## ***Landscape Briefing Note 4***

*Project:* 1080 East Anglia One North and East Anglia Two  
*Date:* 10<sup>th</sup> December 2020  
*Purpose:* Notes responding to SPR's Deadline 2 submissions  
*Reference:* 1080 BN04 Deadline 3.docx

**Plate 4.2 Outline Landscape Mitigation Plan (OLEMS (document reference 8.7))**

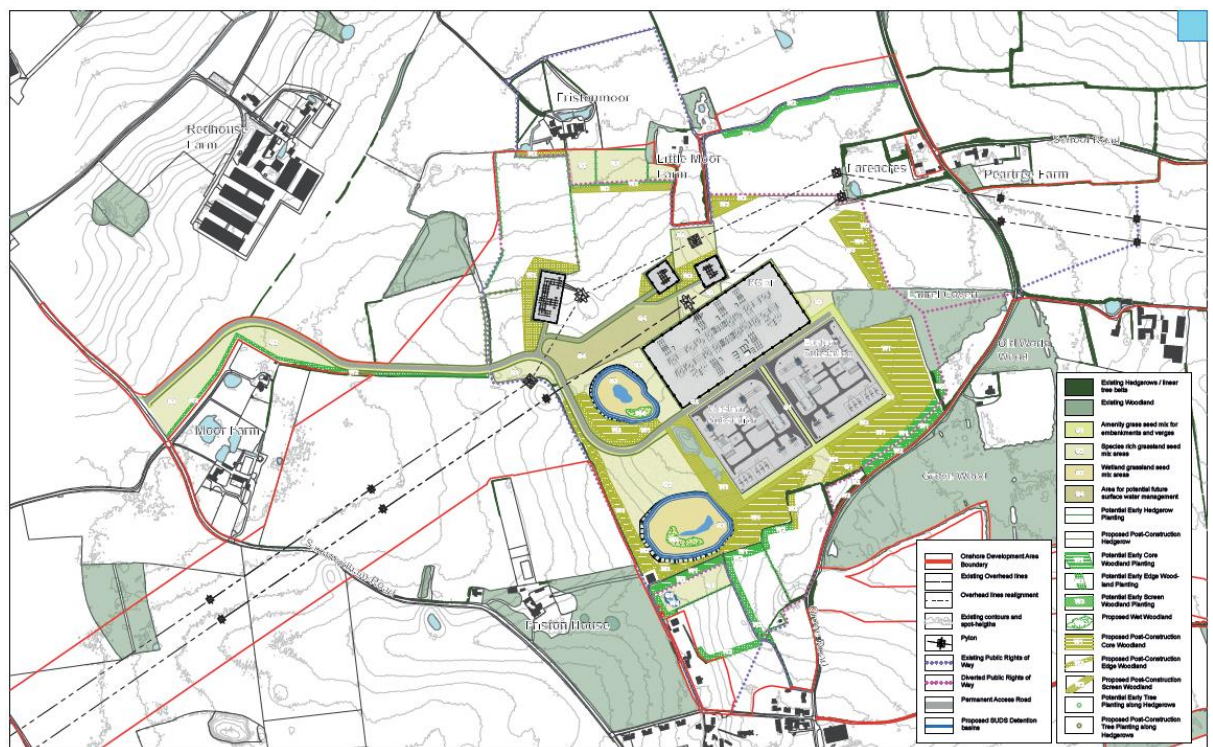
3. SPR have provided no information on how the mitigation planting would be phased should the substations be built consecutively. This implies that the mitigation planting cannot be commenced until both substations have been completed, which will be several years after the Yr 1 operational date for the first substation if they are built sequentially. This increases the period when there would be unmitigated major landscape harm and unmitigated major harm to the visual amenity of residents of Friston and other users of the PRow network to the north of Friston. It also extends the date by which the Yr 15 mitigation shown in SPR's visualisations, which is already highly optimistic with regards to tree growth rates, would be achieved.

6. Whilst the reduced footprint of the SPR substations will allow the retention of the existing copse, and this is welcomed, the reduction will not be significant enough to reduce the magnitude of change for either landscape or visual effects which will remain as **major adverse** during construction and through Year 1 (potentially a six-year period or longer) only reducing to **moderate/major** at year 15 based on highly optimistic assumptions with regard to tree growth rates.
